Ribble Valley Borough Council

DELEGATED ITEM FILE REPORT - REFUSAL

Application No:	3/2015/0517/P (PA)
Development Proposed:	Single storey extension to rear and extension of curtilage to create a walled back garden at Wolfen Hall, Fish House Lane, Chipping

Proposed
extension.

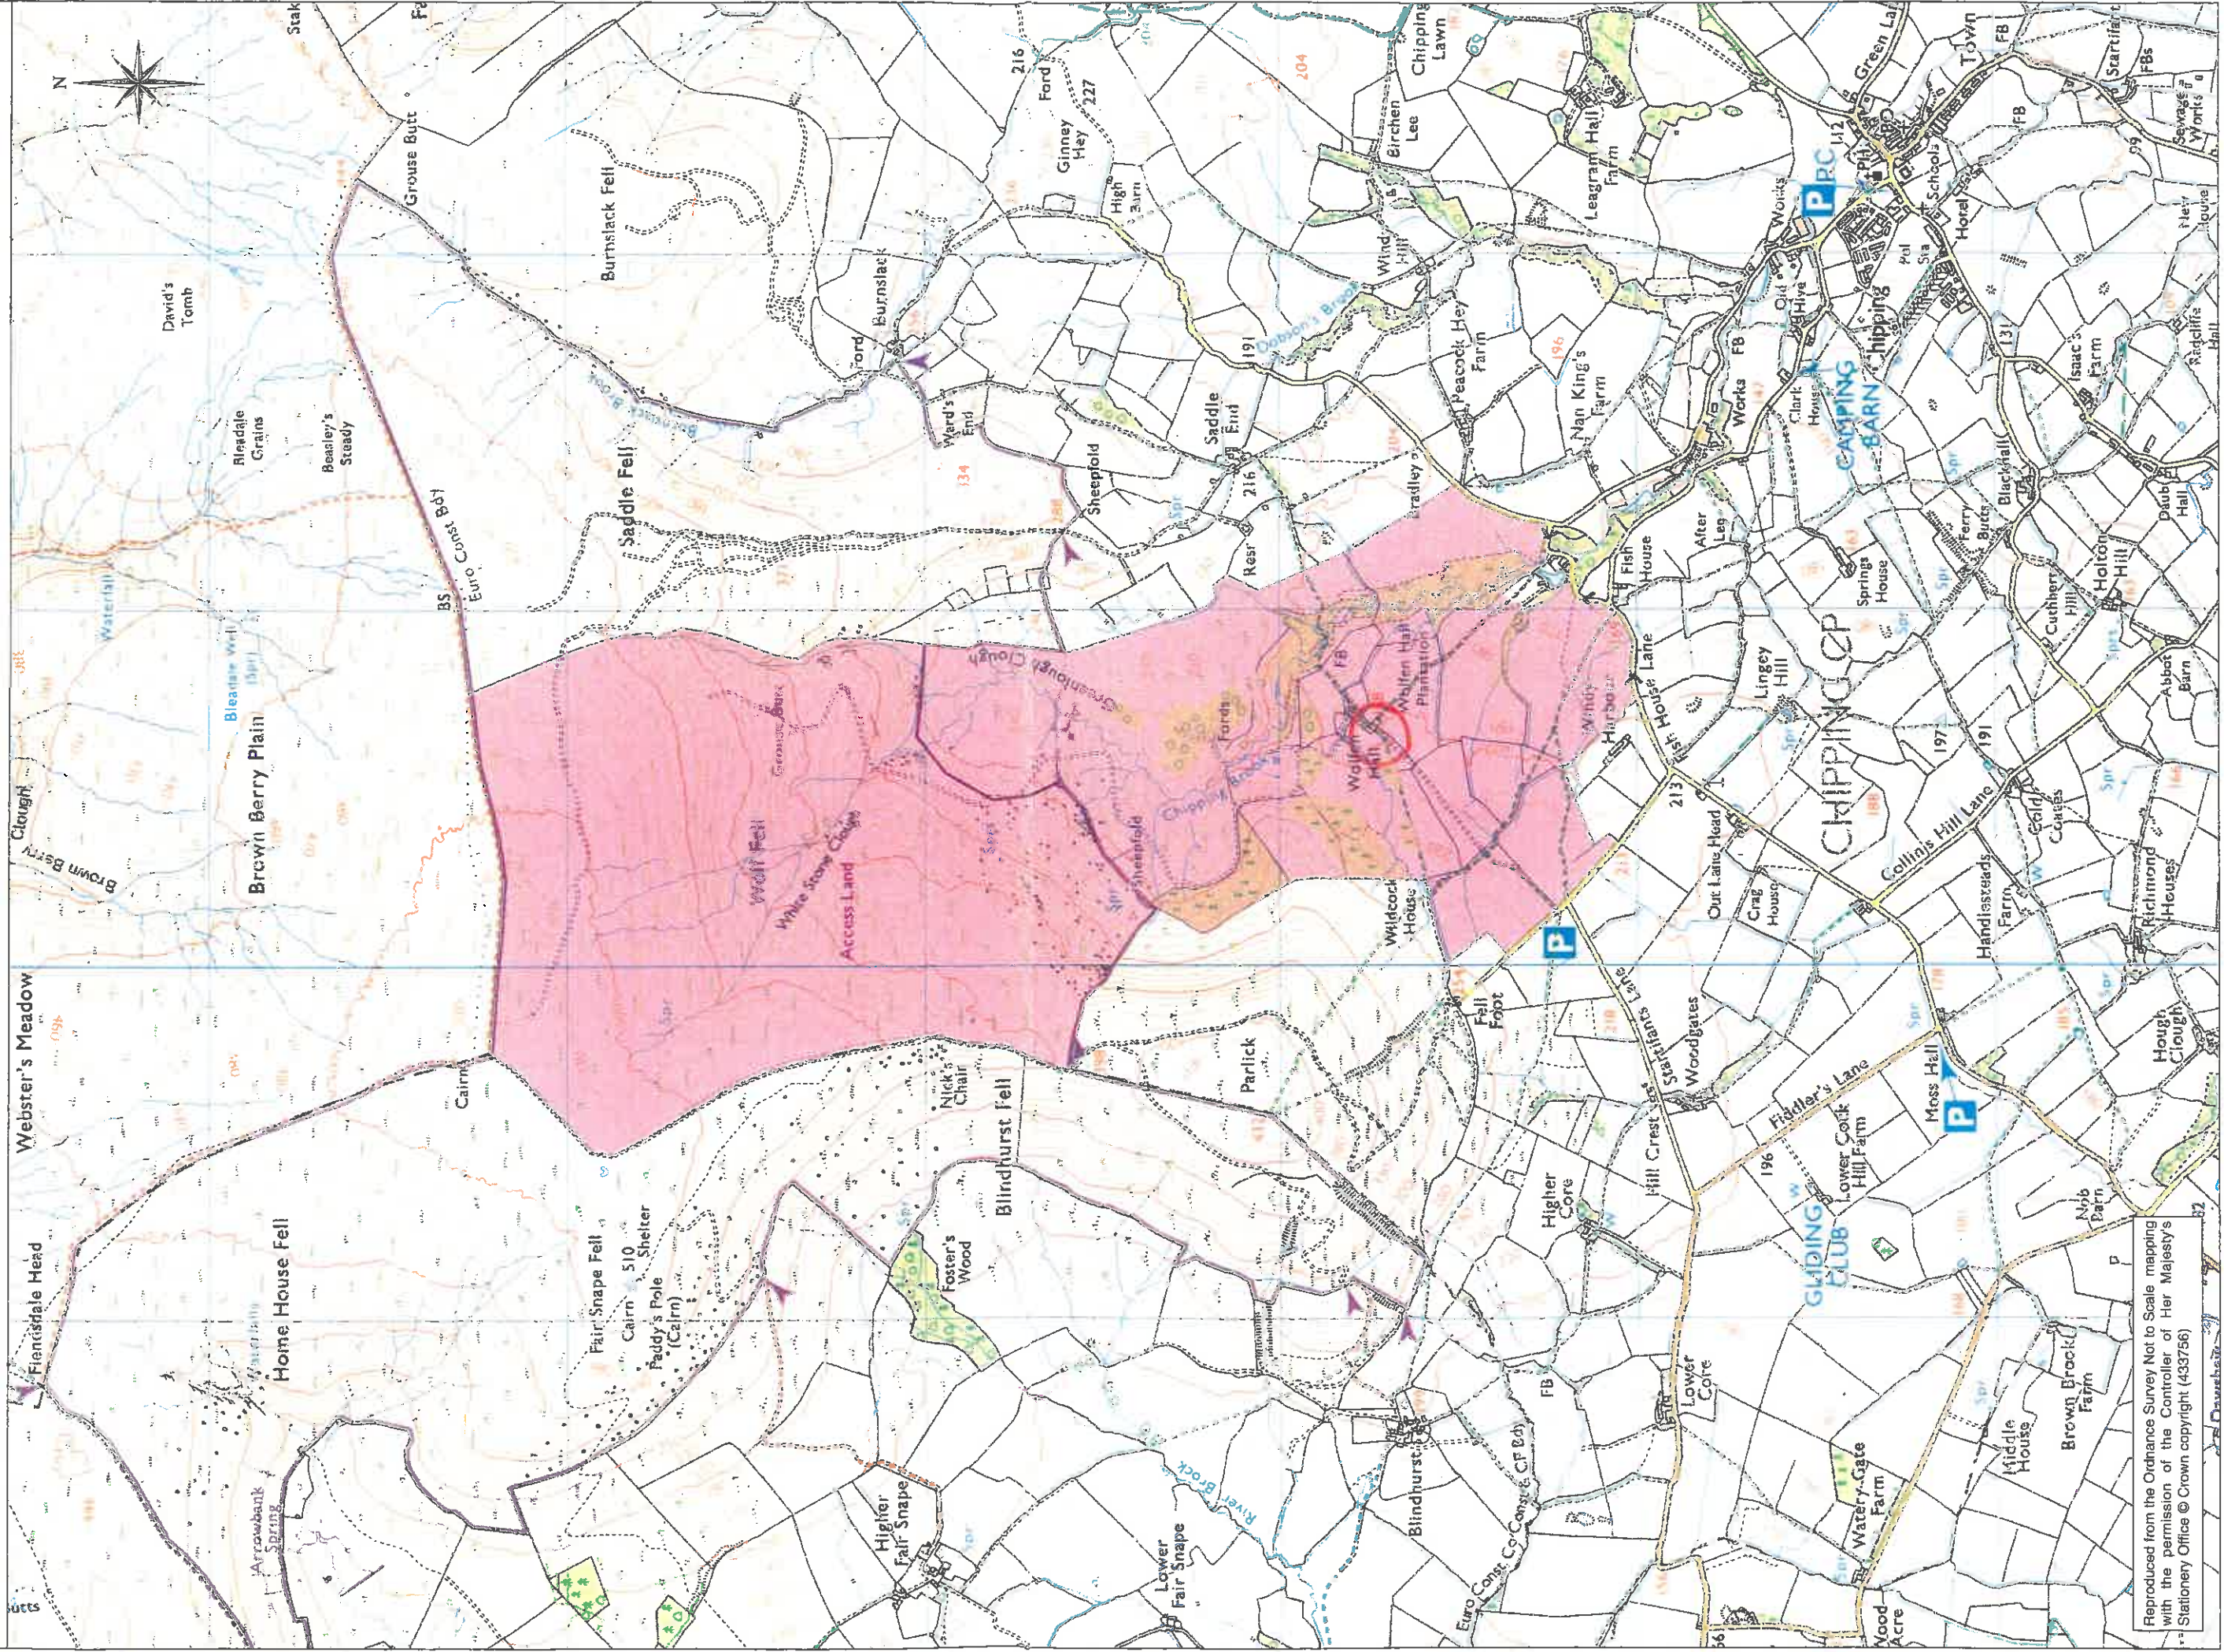
The sketch drawing appears to be from an elevated viewpoint (wall top at same height as adjoining window sill) which does not convey the impact of the proposed 1.8m enclosing wall.
